Prmt	Text93	30004	Constr Type	New	Num1	5	
Permit Nbr	05-1490	Location of Construction	11	PIERCE AVE	Appl. Date	1	
Status	Hold	Permit Type	Additions - Dwellings		Issue Date		
CBL	250 A018001	District Nbr	3	Estimated Cost	\$71,000.00	Date Closed

TO: <u>Jeff</u>	FROM: <u>Tammy Munson</u>
FAX NUMBER: <u>799-3292</u>	NUMBER OF PAGES, WITH COVER: <u>4</u>
TELEPHONE: _____	RE: <u>11 Pierce</u>
DATE: <u>10/21/05</u>	_____

ONE AND TWO FAMILY	PLAN REVIEW	CHECKLIST
Soil type/Presumptive Load Value (Table R401.4.1)	Submitted Plan	Findings/Revisions/Dates
<b>STRUCTURAL</b> Footing Dimensions/Depth (Table R403.1 & R403.1(1), (Section R403.1 & R403.1.4.1))	OK - 4' Post	
Foundation Drainage, Fabric, Damp proofing (Section R405 & R406)	N/A	
Ventilation/Access (Section R408.1 & R408.3) Crawls Space ONLY	SIZES?	
Anchor Bolts/Straps, spacing (Section R403.1.6)	NOT SHOWN	
Lally Column Type (Section R407)	OK	
Girder & Header Spans (Table R 502.5(2)) Built-Up Wood Center Girder Dimension/Type	N/A	
Sill/Band Joist Type & Dimensions First Floor Joist Species Dimensions and Spacing (Table R502.3.1(1) & Table R502.3.1(2))	2x6 PT SILL 2x10's - 16" OC - Max span 15'-5"	15'-2" span - OK
Second Floor Joist Spe

FLOOR PLAN

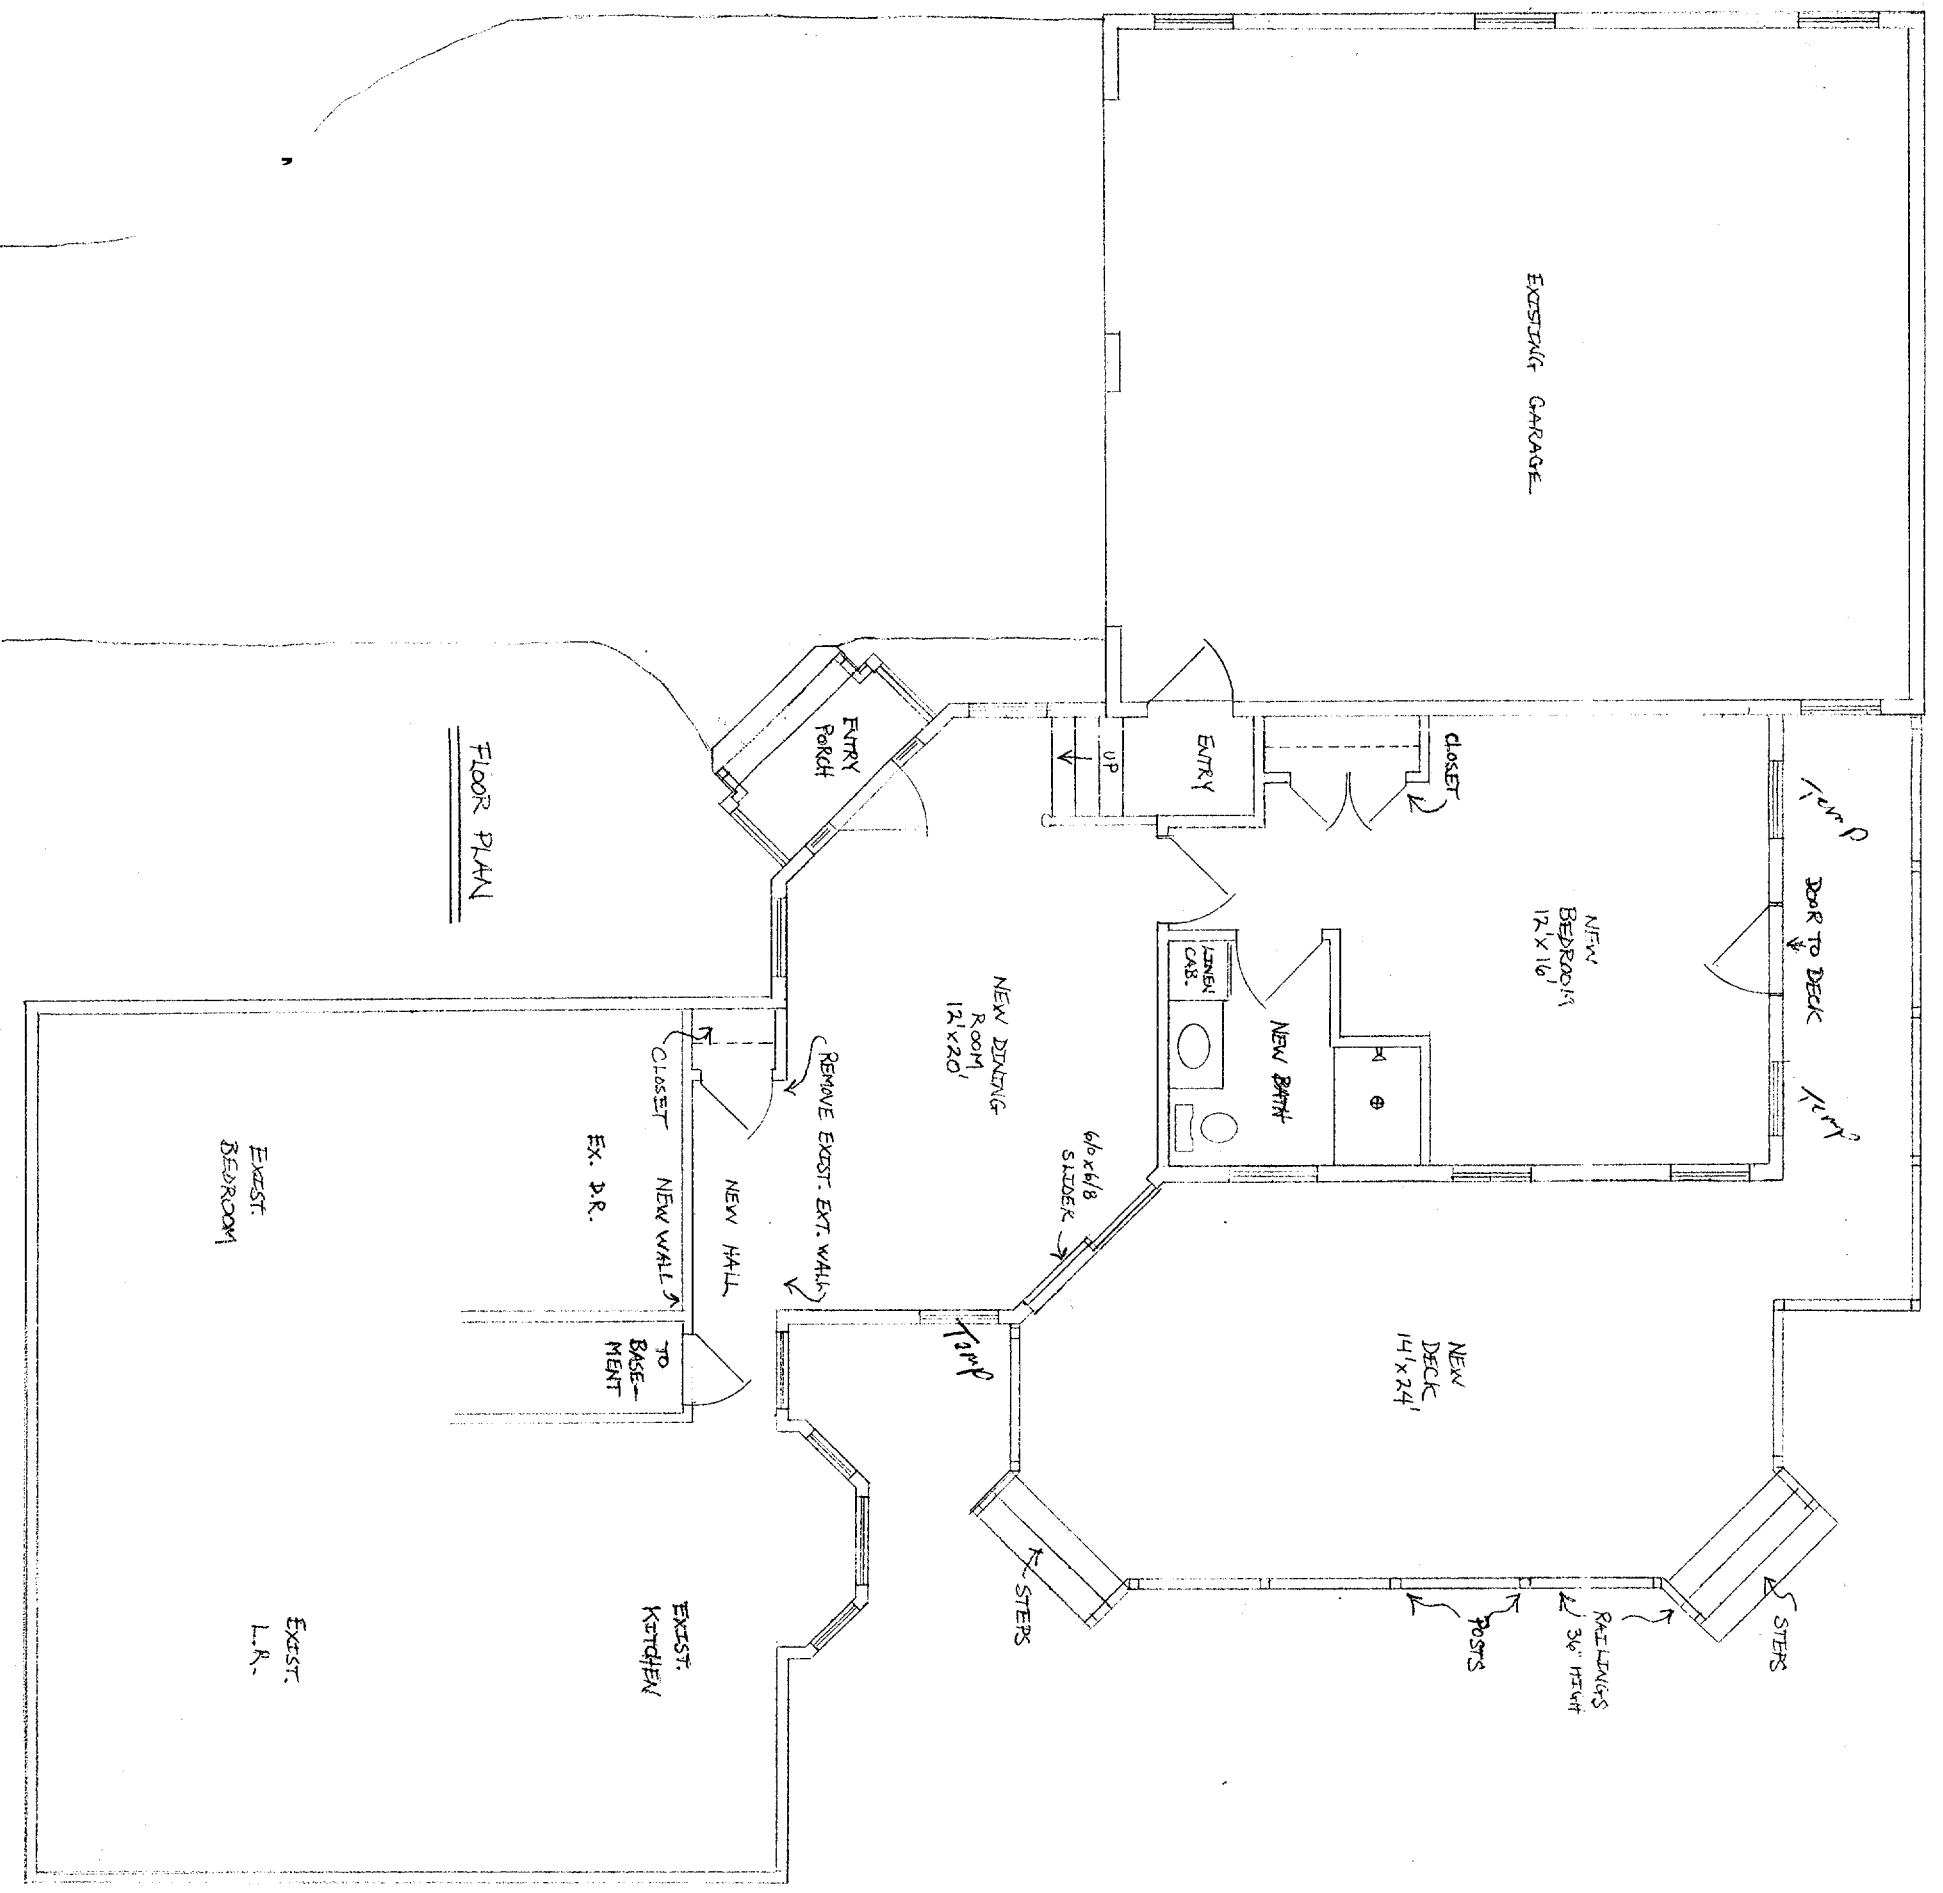
<p>R802.4(2))</p>	<p>Pitch, Span, Spacing &amp; Dimension (Table R802.5.1(1) - R 802.5.1(8)) Roof Rafter; Framing &amp; Connections (Section R802.3 &amp; R802.3.1)</p>	<p>OK</p>	<p>3/4 Floor - 5/8 Roof - walls? 7/16" o.s.B</p>
<p>Fastener Schedule (Table R602.3(1) &amp; (2))</p>	<p>Private Garage (Section R309)</p>	<p>1/2" to ridge / <del>door?</del></p>	<p>? 5/8" fire rated on garage wall next to bedroom</p>
<p>Living Space? (Above or beside)</p>	<p>beside</p>	<p>door?</p>	<p>Steel Fire Rated - 40 minute</p>
<p>Fire separation (Section R309.2) - need</p>	<p>Opening Protection (Section R309.1)</p>	<p>OK - door -</p>	<p>Asphalt?</p>
<p>Emergency Escape and Rescue Openings (Section R310)</p>	<p>Roof Covering (Chapter 9)</p>	<p>Asphalt?</p>	<p>3 Tab Asphalt</p>
<p>Safety Glazing (Section R308)</p>	<p>Artic Access (Section R807)</p>	<p>Need w/in 2' of door</p>	<p>Tempered on flankers next to window</p>

<p>Chimney Clearances/Fire Blocking (Chap. 10)</p>	<p>Header Schedule (Section 502.5(1) &amp; (2))</p>	<p>Not shown</p>	<p>Through Bedroom Closet</p>
<p>Energy Efficiency (N1101.2.1) R-Factors of Walls, Floors, Ceilings, Building Envelope, U-</p>	<p>R-30 Floor/Cing</p>	<p>Not shown</p>	<p>3-2x8 w/ 1/2" ply between</p>

ROOF FRAMING PLAN

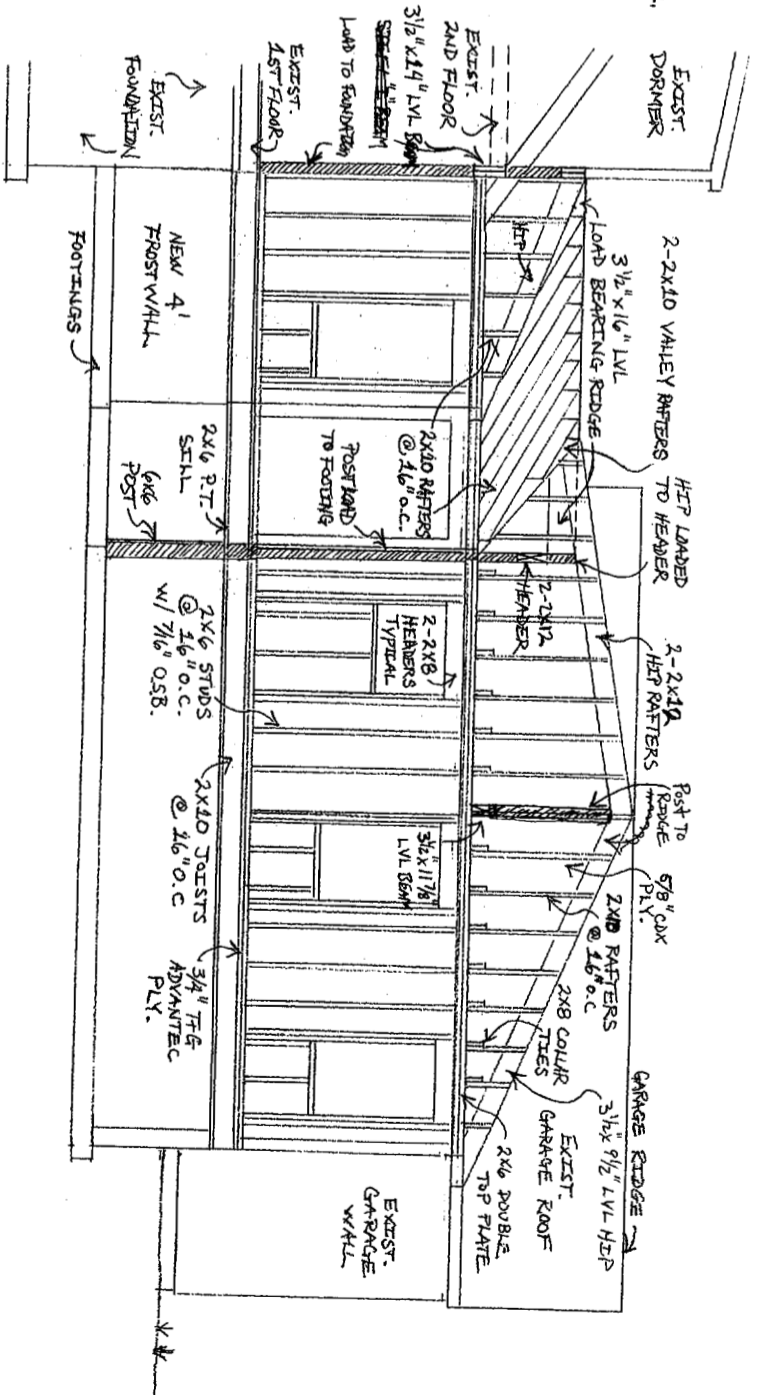
Need details on all ledgers - addition deck & addition
